Your Ref: OWPC24585
Our Ref: M/80/19/PL 16-09-2019
Please ask for:
Mrs A Gardner

Demolition of the existing structures & redevelopment to provide a new 66-bedroom care home (Use Class C2) arranged over two storeys together with associated access, car and cycle parking, structural landscaping and amenity space provision
Former Poultry Farm Land West of Yapton Road Middleton on Sea

Drawing no: PJC/5256/19/C	Rev: -	Sheet number: 1 of 4
Client and site: Edmonds Williams Ltd		
Yapton Road Middleton-on-Sea PO22 6SE		
Drawing title: Tree Protection Plan		
Date drawn: 28/08/2019		
Scale: 1:200 at A3		
Drawn by: LR	Checked by: PD

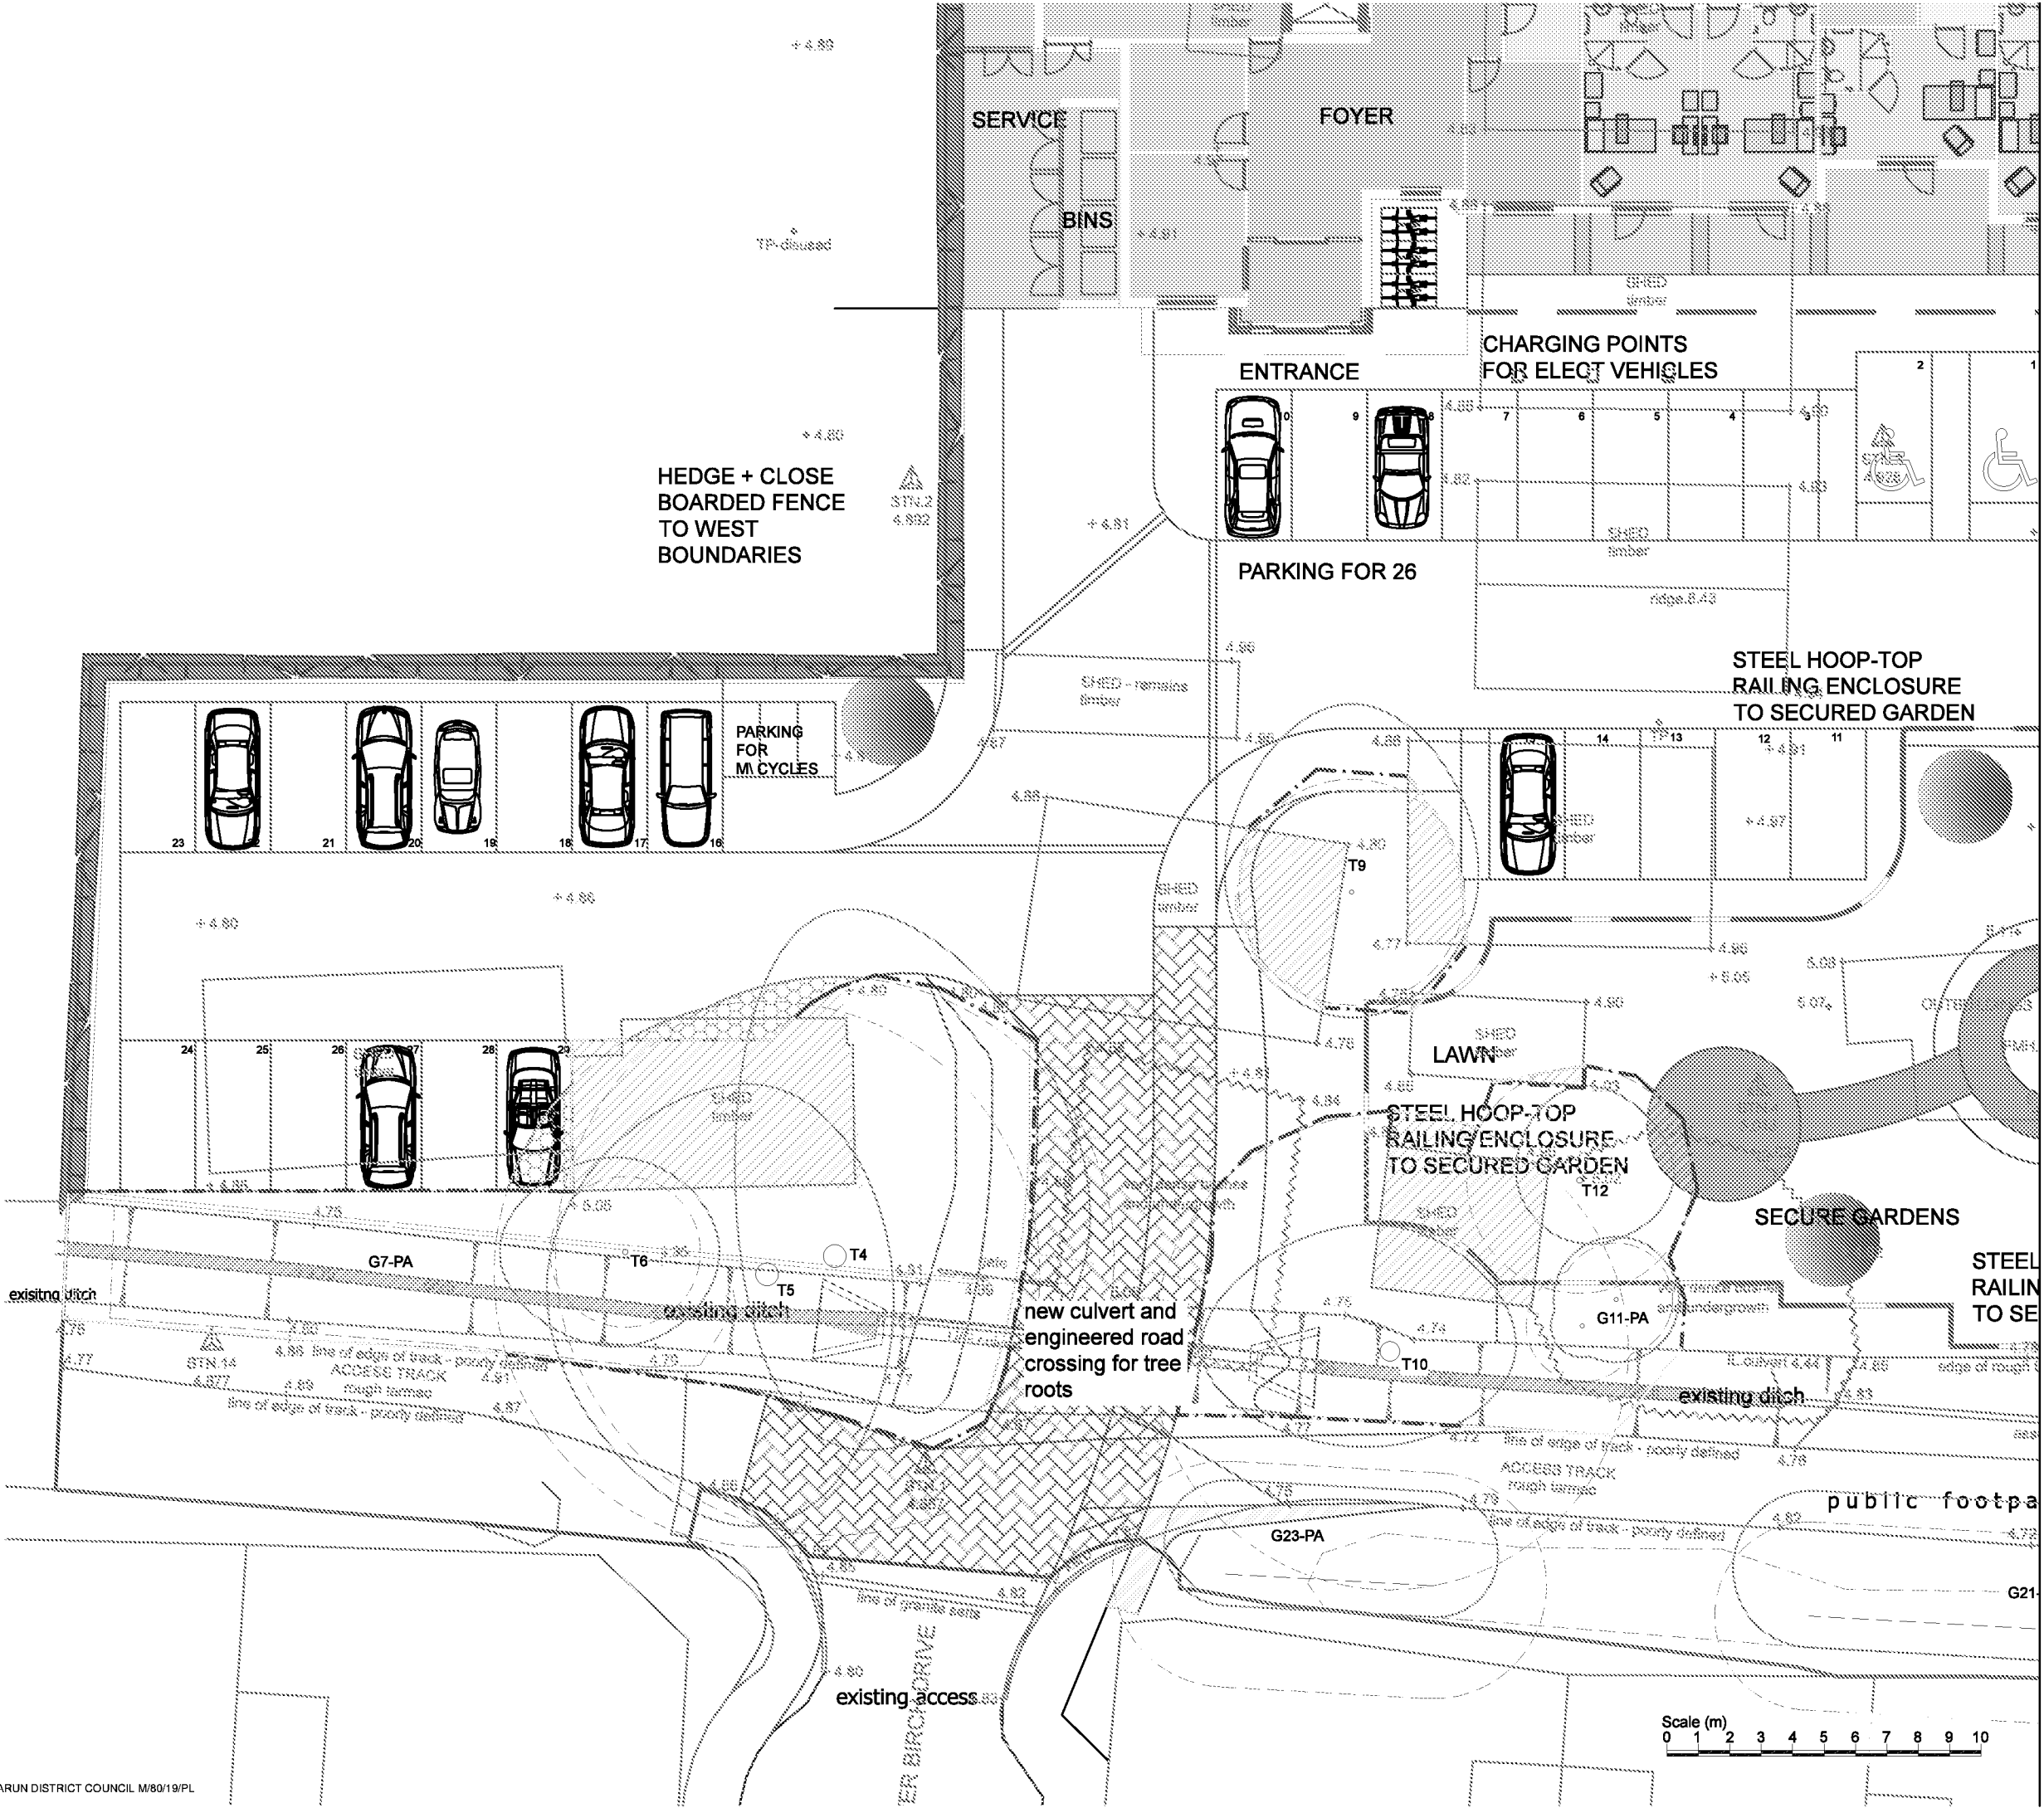
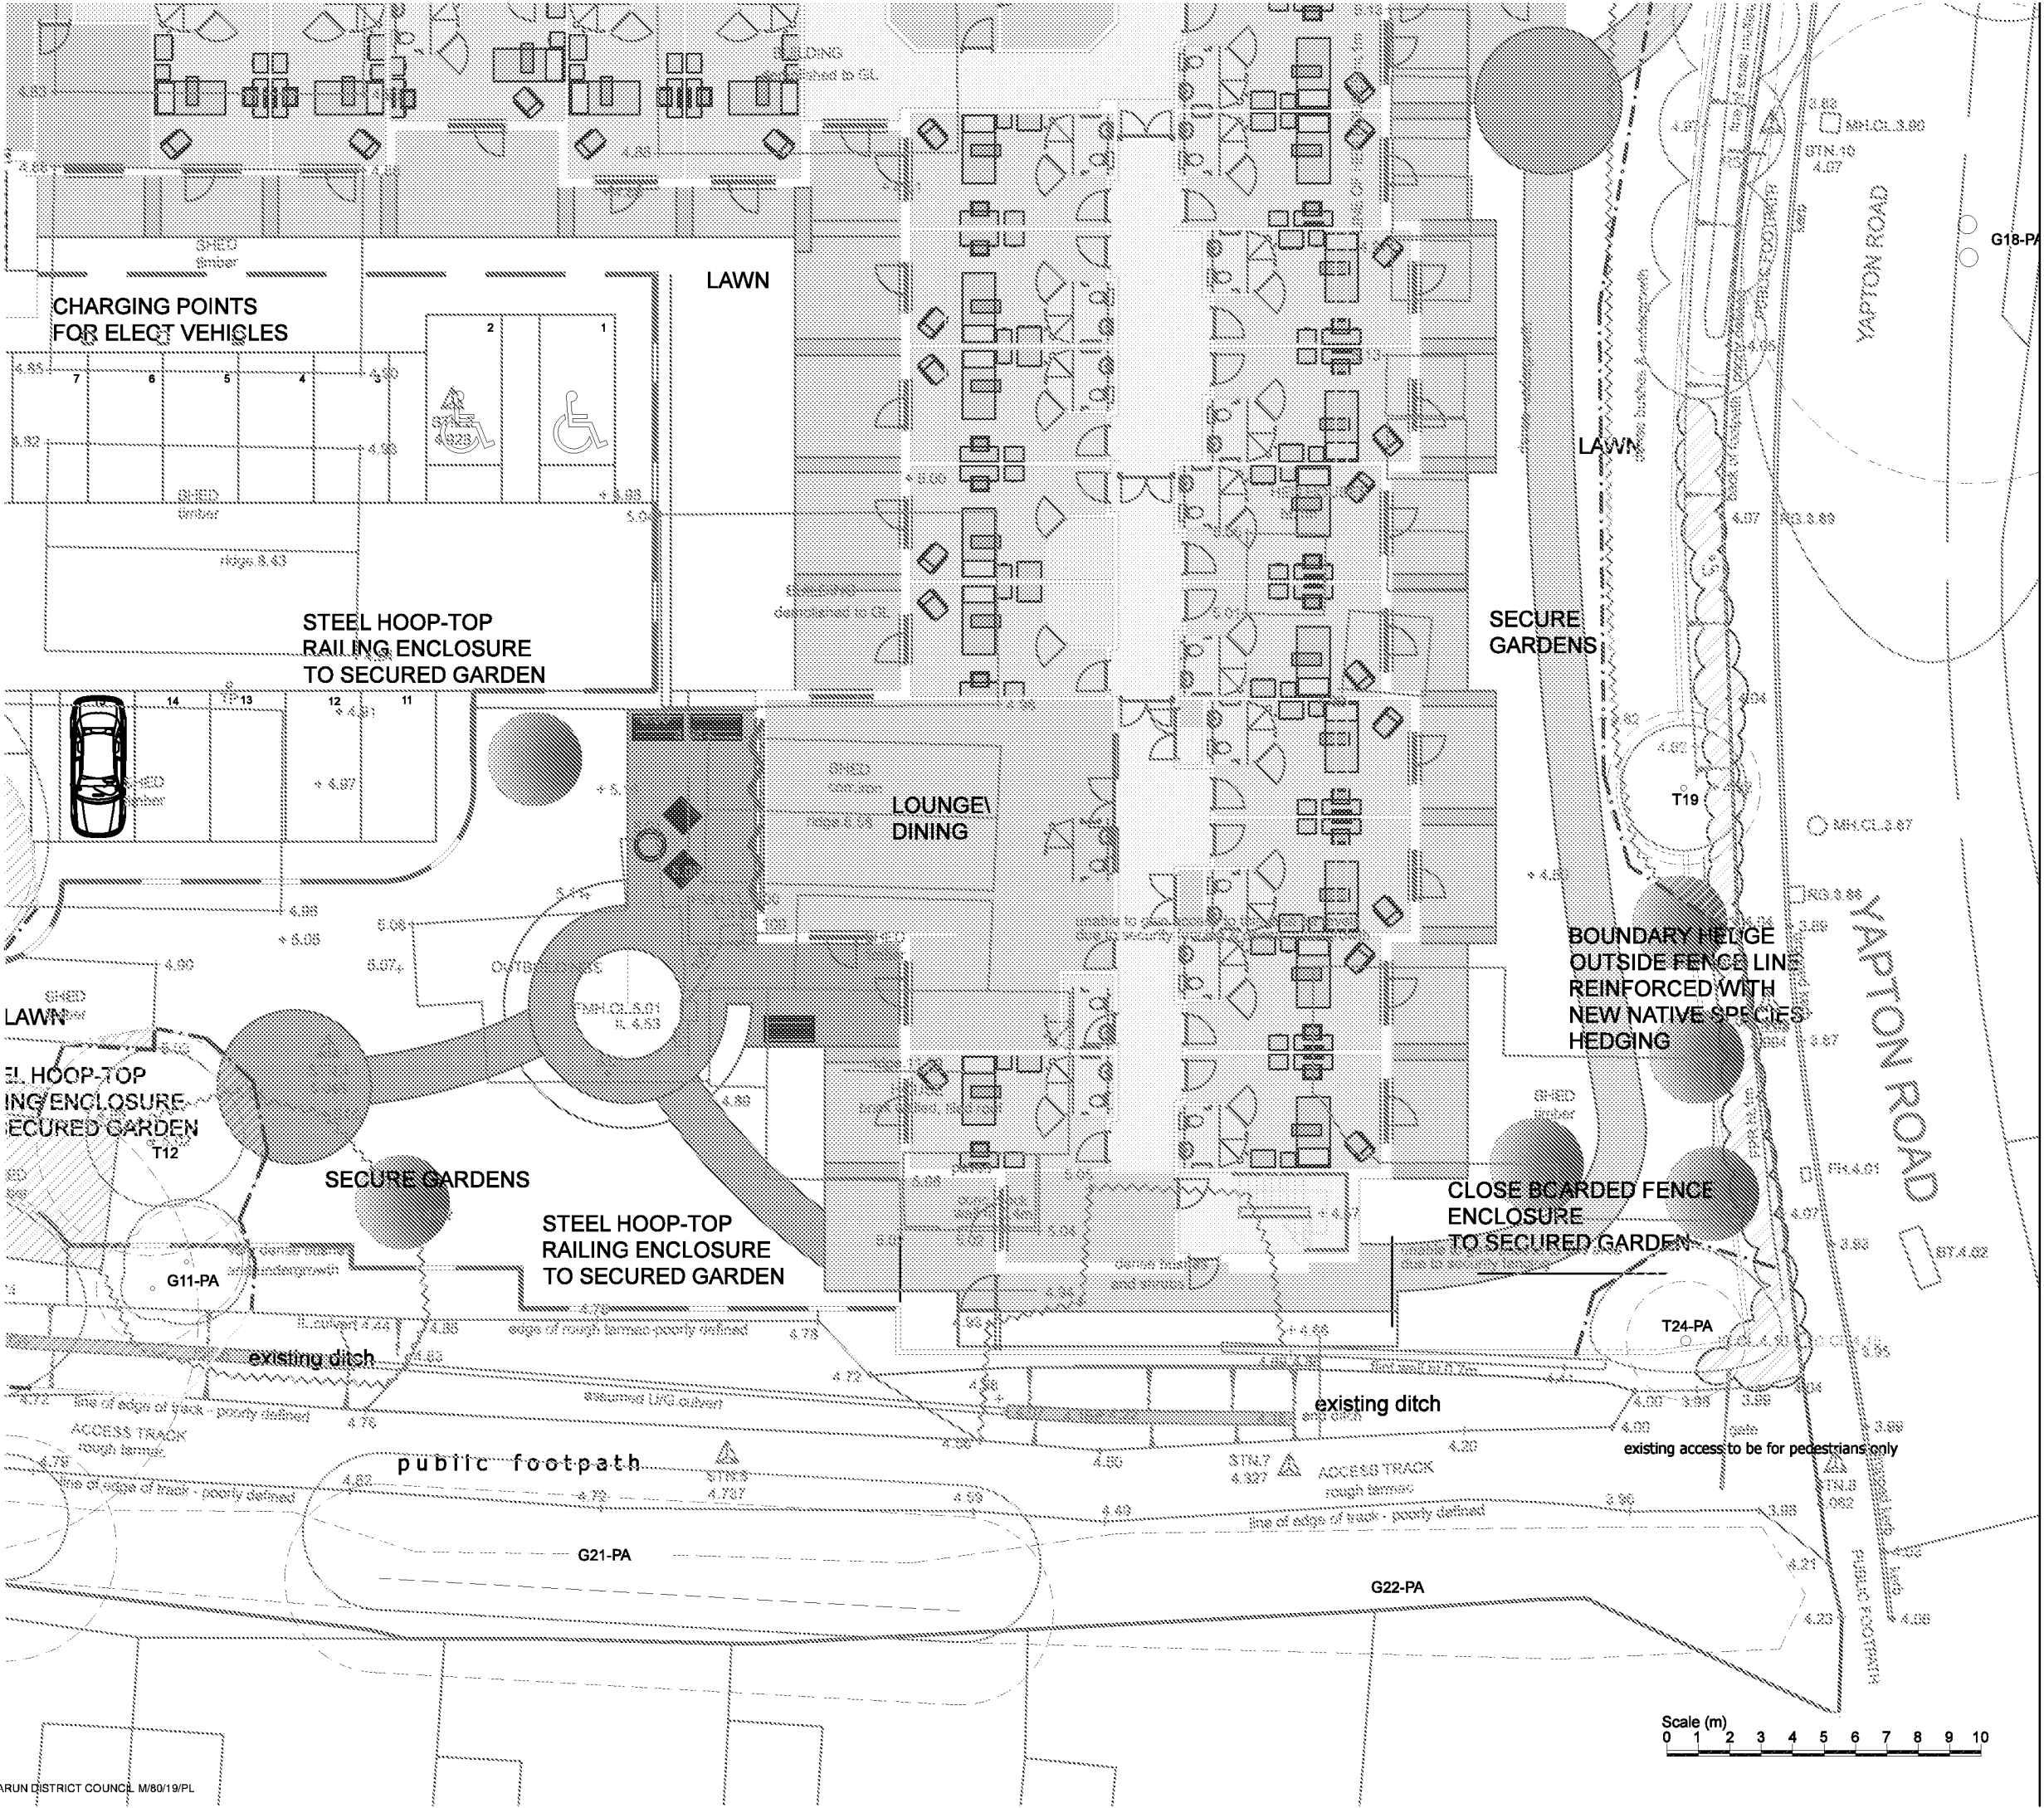
3, Ash tree, with a Tree Preservation Order fouling proposed access road onto site. The developer claim that they would protect the roots of this tree with a commercial system that has been used in similar situations, with, they claim success. However what they have not acknowledged is that a number of the tree's boughs and branches, hang very low over the width of the proposed entrance road, the lowest of which is only just over 2 metres above the proposed carriageway. These would have to be removed from the tree on day one to allow construction plant and vehicles to access the site and, in addition, pruning would need to be ongoing to ensure access to the site could be maintained. This work would involve substantial amount's of damage to the tree and on fears for it's long term health. In conclusion, we believe the proposed access to this site is not practical without severely damaging the tree with a TPO on it. We believe the developer should either find an alternative way onto the site or at the very least slew the access away from the Ash tree to minimise possible damage to roots, boughs and overhanging branches
